21 February, 2018

RE: STAGE 1 DA (LOT 2) EASTERN CREEK BUSINESS HUB

1. As requested, we have reviewed the traffic matters raised by RMS, TfNSW, Blacktown Council and Planning and Environment with respect to the Stage 1 DA for Lot 2 within the Eastern Creek Business Hub. We prepared the traffic assessment for the Stage 1 DA (Eastern Creek Business Hub Stage 1 DA - Proposed Retail Centre Lot 2 – Traffic Report, September 2017). The matters raised and our response is set out below.

**12.5m LARGE RIGID VEHICLE  
 SWEEP PATHS**

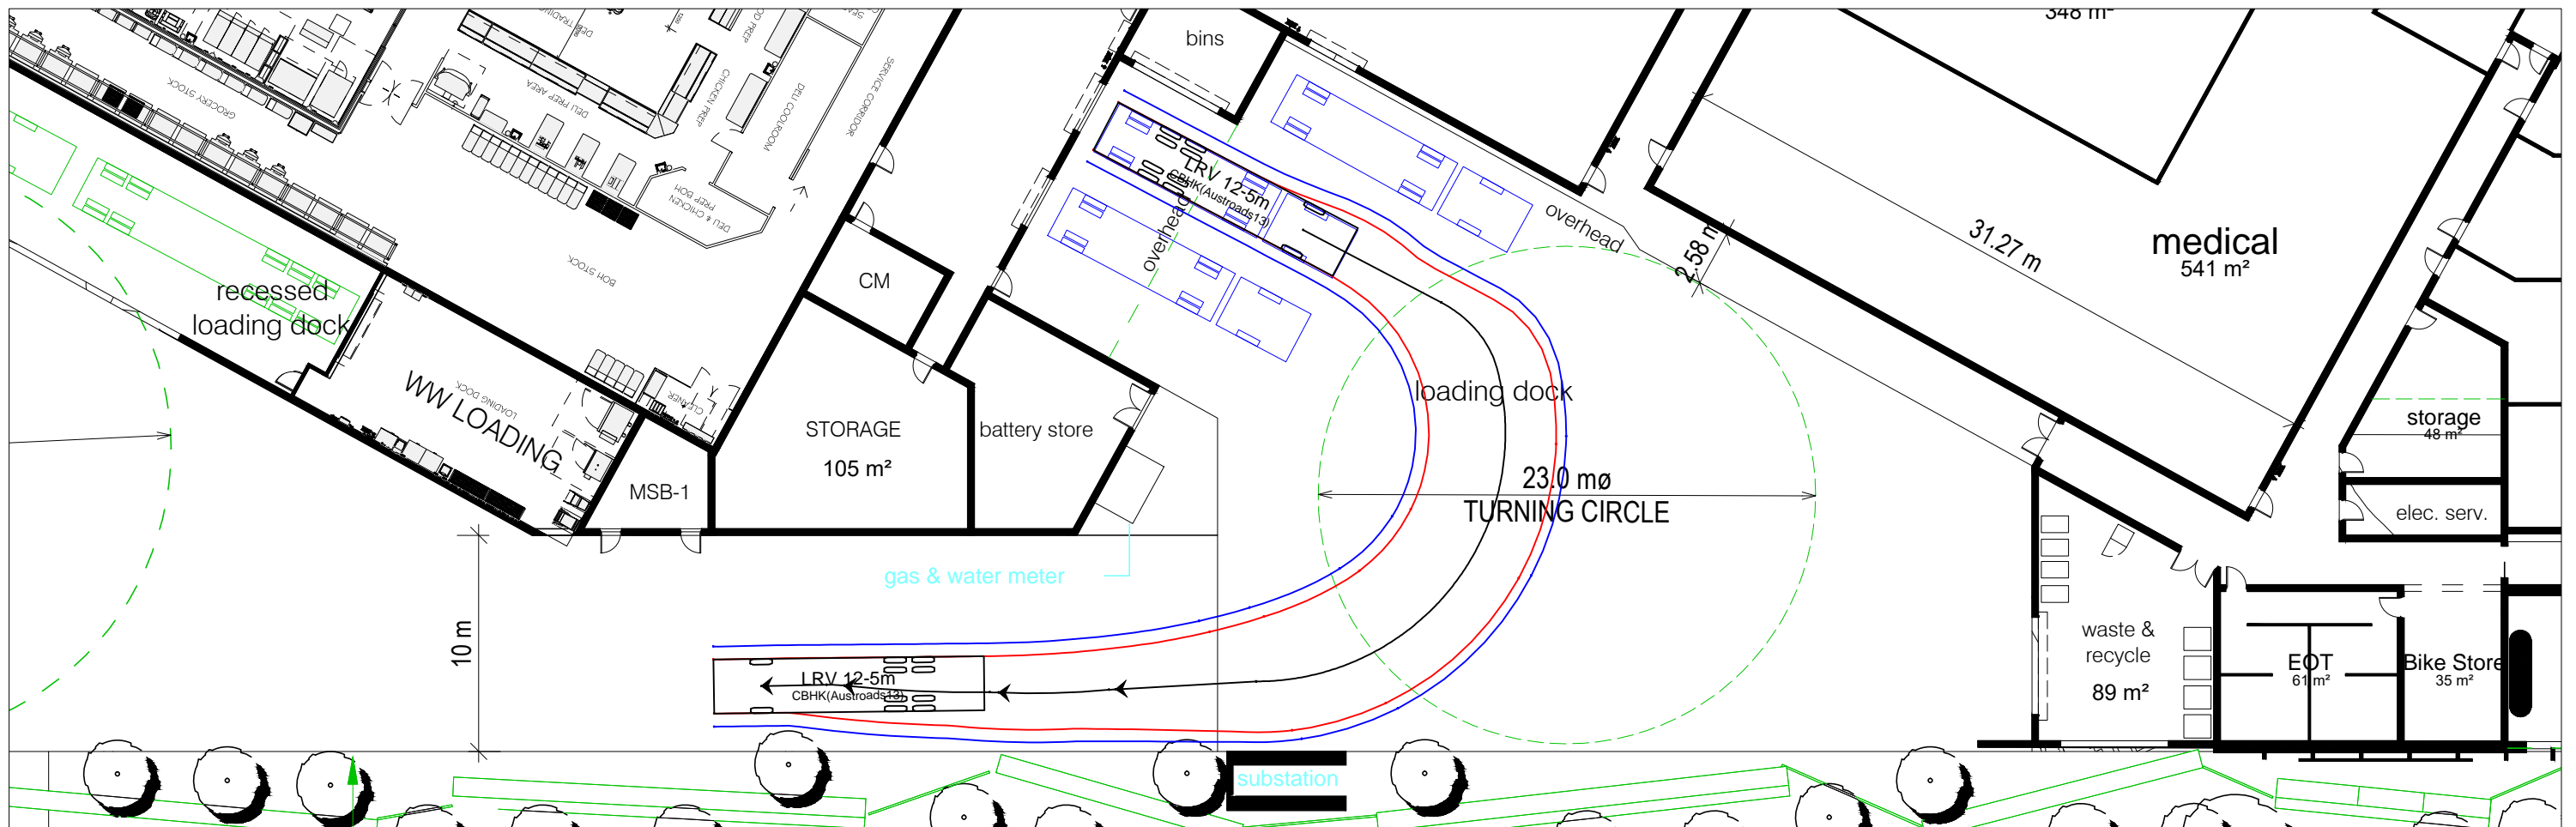
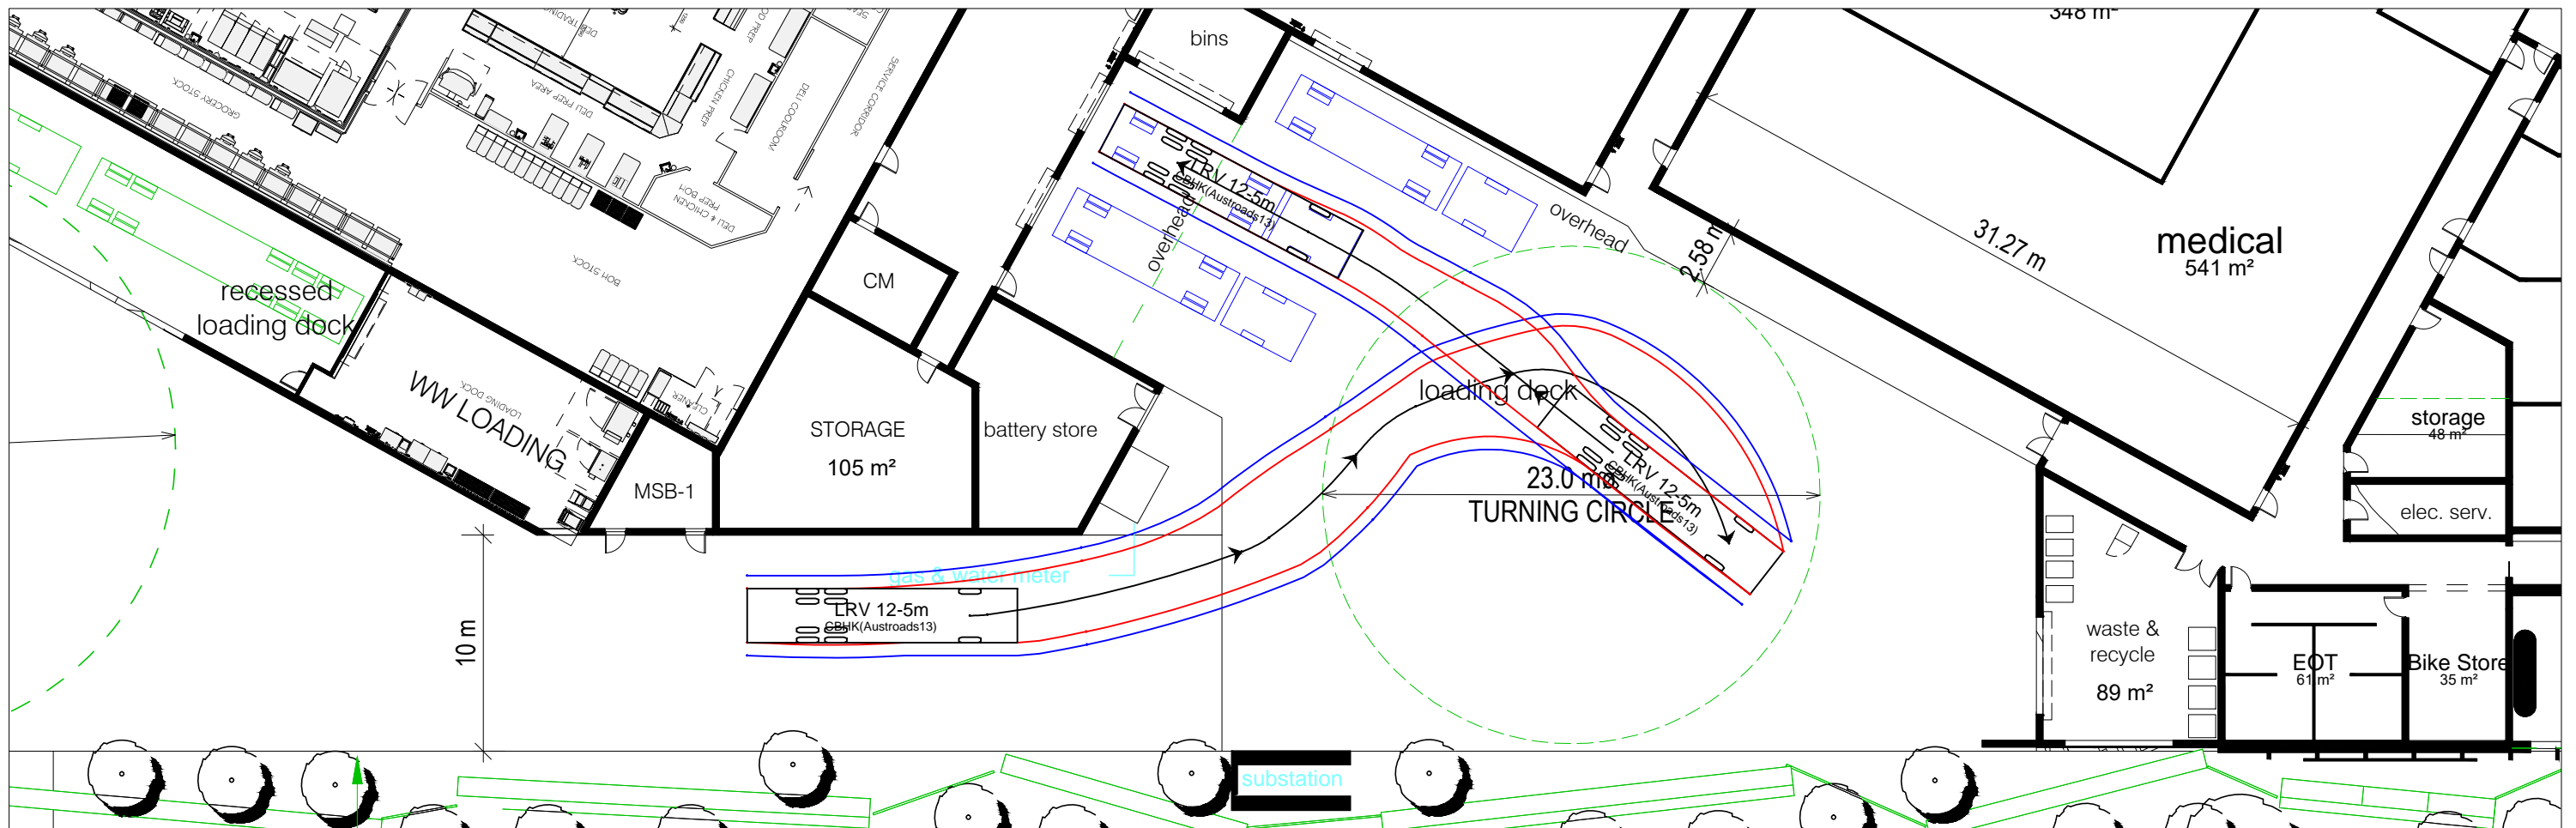
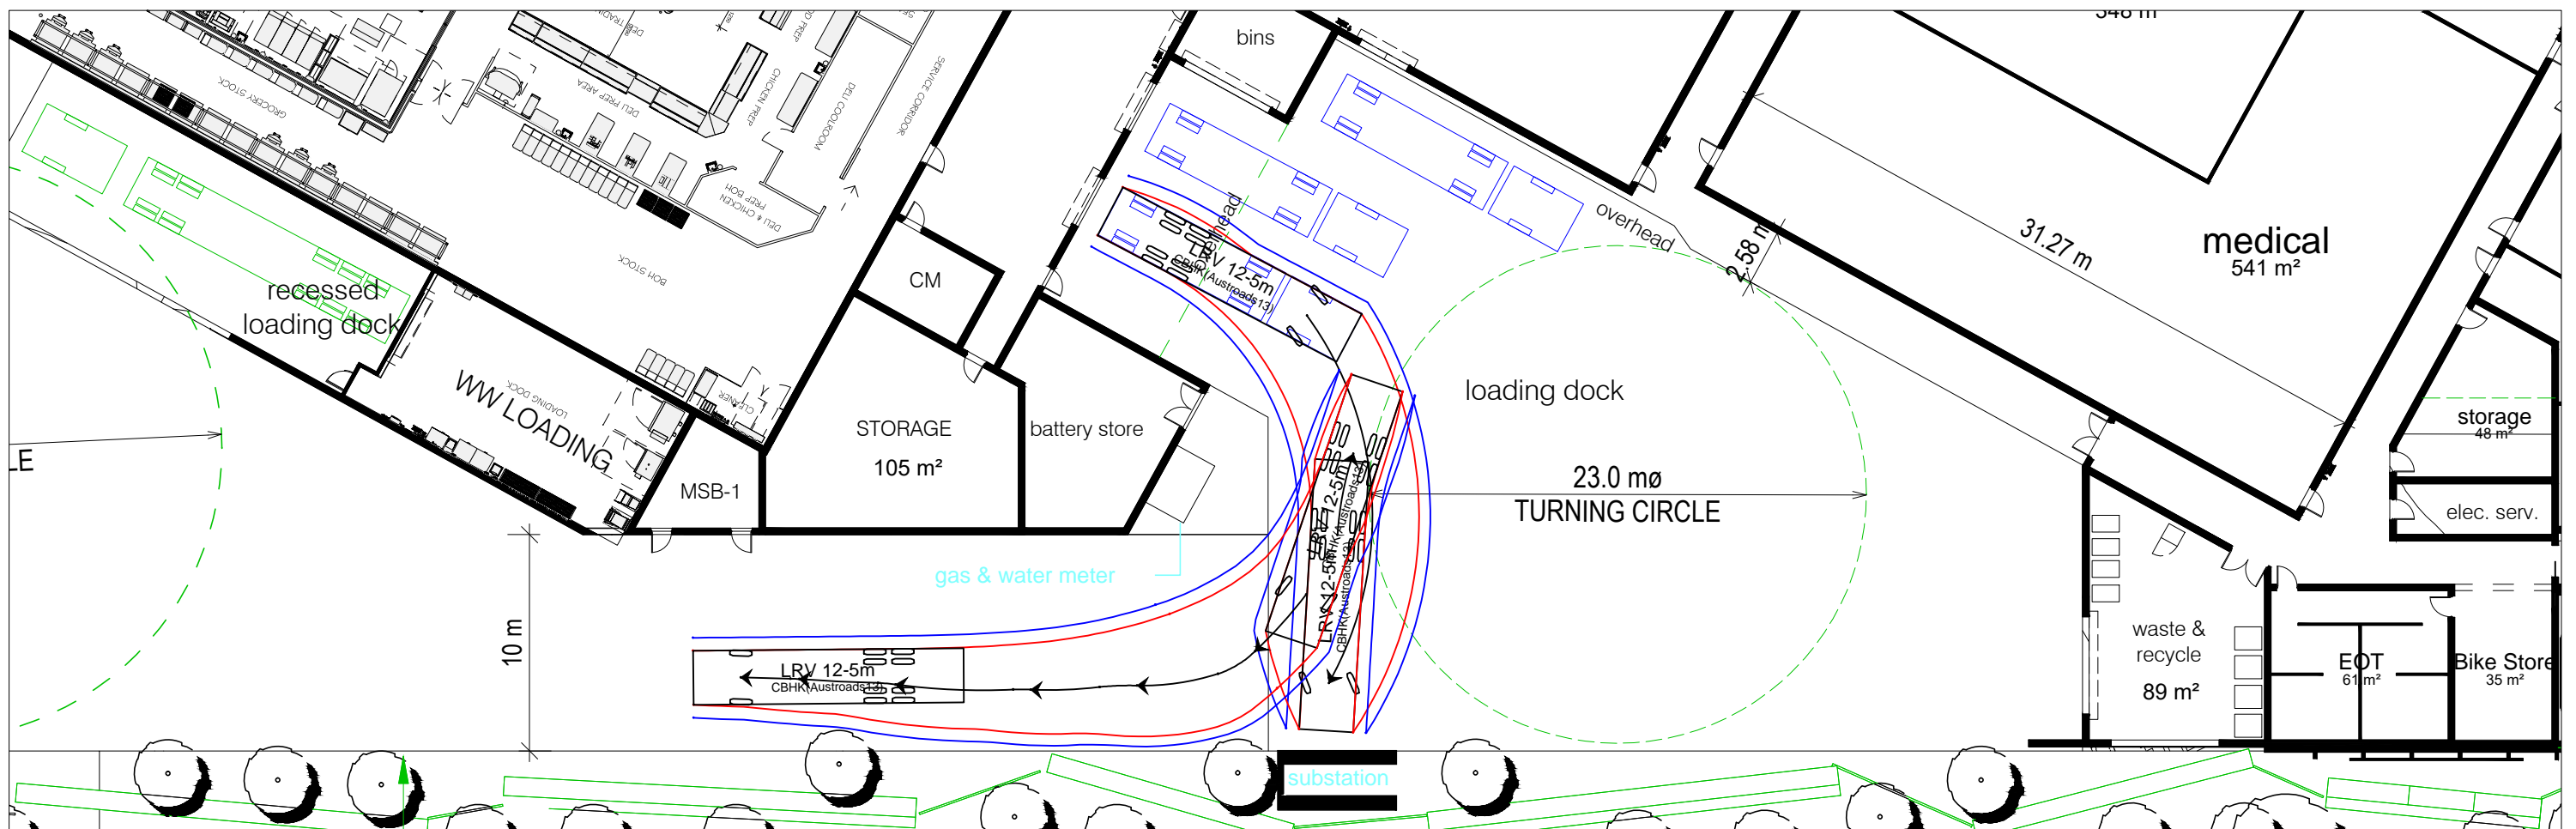
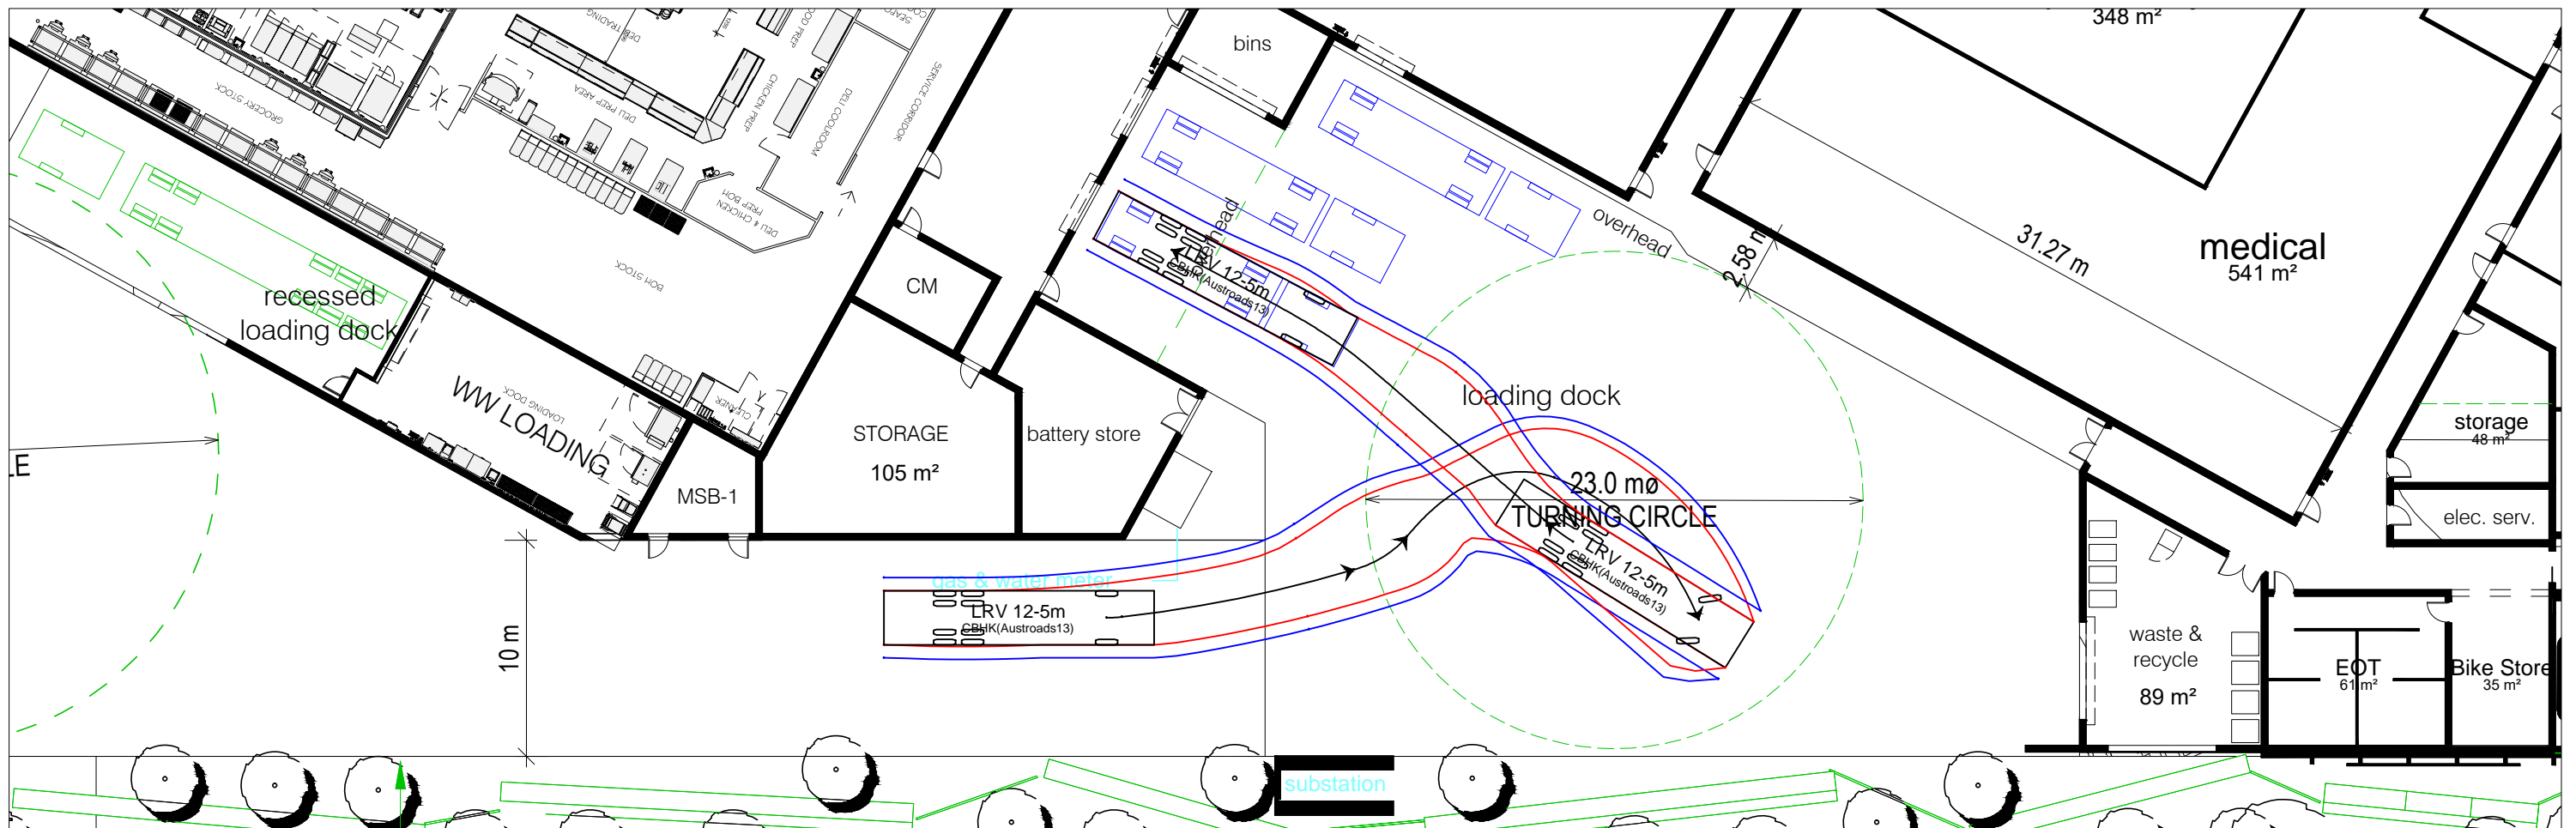
10. In its letter dated 29 November 2017, Council raised the following traffic matters:
 - Beggs Road should have a carriageway of 13.5 metres and a turning head in the form of a cul-de-sac with a 13.5 metre radius.

11. With regards to Beggs Road this will be a short dead end road of limited length (some 80 metres) providing service access to Stage 1 and access to the residential dwelling located on the southeast corner of Beggs Road and Rooty Hill Road South. As shown on the attached plan, the carriageway on Beggs Road has been widened to 13.5 metres. A turning head has been provided that allows a 12.5 metre long truck (including a garbage truck) to make a 3 point turn east of the access to the Stage 1 service area.

12. With regards to the request for a turning head in the form of a cul-de-sac with a 13.5 metre radius this cannot be provided within existing road reserve. It is also not warranted as:

- adequate turning area for a 12.5 metre long rigid truck has been provided (to turn in part of the road not accessed by the any vehicles) and thus to turn around in safely (without conflict to other vehicles);

- the volume of traffic using Beggs Road would be low (less than 10 vehicles per hour two way);
 - the need for a truck to turn around would be very low; and

- the turning area would allow a car to undertake a u-turn.
13. With regards to the other matters raised by Council we note that:
 - the proposed alignment of Beggs Road to Rooty Hill Road South (70 degrees) complies with Council's engineering standards;
